**From:** Martin Hill <Martin.Hill@arun.gov.uk>  
**Sent:** 19 April 2022 11:40  
**To:** Planning.Responses <Planning.Responses@arun.gov.uk>  
**Subject:** RE: Planning Consultation on: BR/48/22/PL

Comments from Private Sector Housing:

**Application No:** BR/48/22/PL  
**Registered:** 7th April 2022  
**Site Address:** 13-17 Richmond Avenue Bognor Regis PO21 2YE  
**Grid Reference:** 492499 98986  
**Description of Works:** Conversion of existing loft space into 2 No flats. This application is in CIL Zone 4 (Zero rated) as flats.

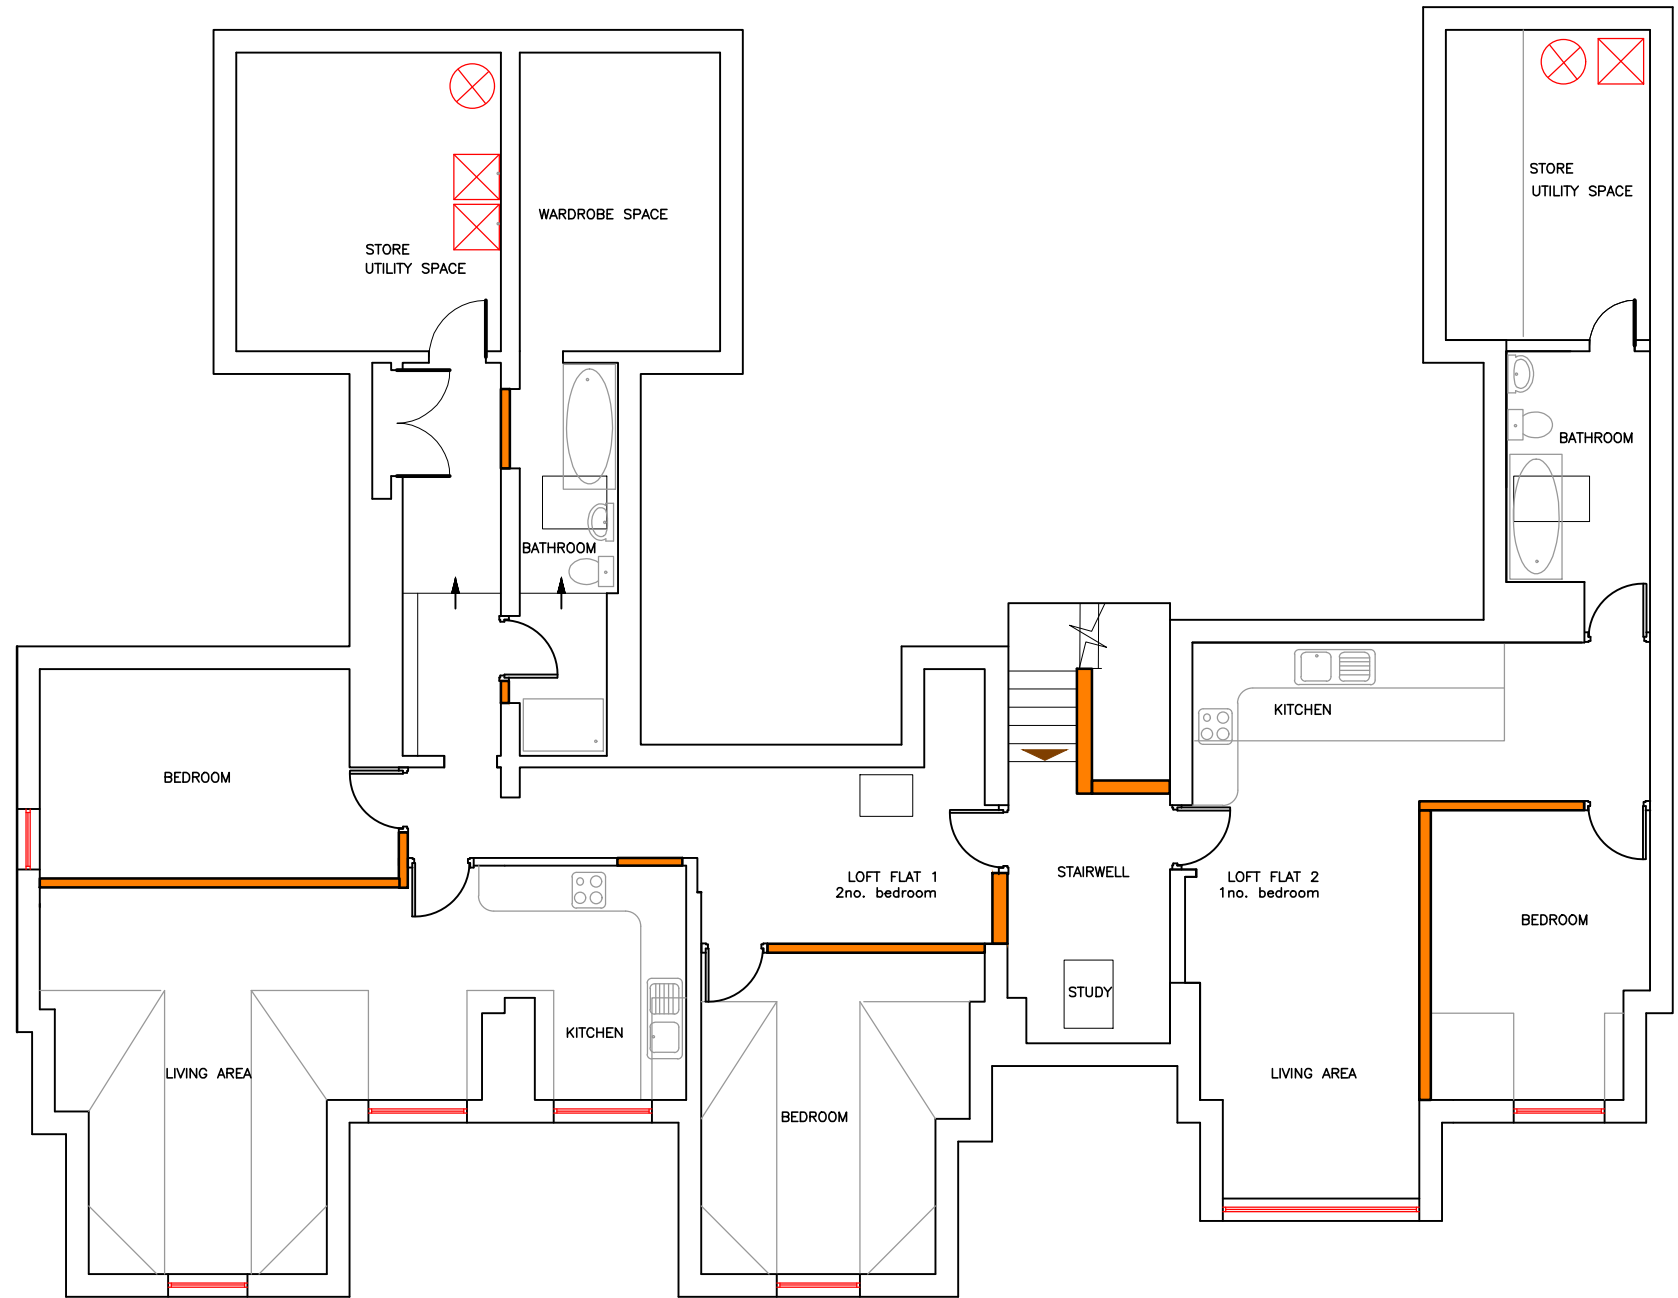
- There must be a minimum 30 minutes fire separation between each flat, both vertically and horizontally.
- It is noted that there is a Study identifiable on the proposed plan on the second floor landing. A study or any combustible items or sources of ignition must not be located in this area, which serves as an emergency escape route. This may be a typo and perhaps intended to show a skylight?

- Any bathrooms and kitchens without windows for natural ventilation should have adequate mechanical ventilation. Mechanical extraction should be installed in the kitchen area of Flat 2 due to the location of the only available window being in the living area, rather than near to the cooking facility.
- All habitable rooms must have an opening window, equivalent to 1/20<sup>th</sup> of the floor area, to the outside air to provide adequate ventilation. French or patio doors that have no separate openable casements, or where there is no alternative openable casement within the room, are not considered acceptable in bedrooms.
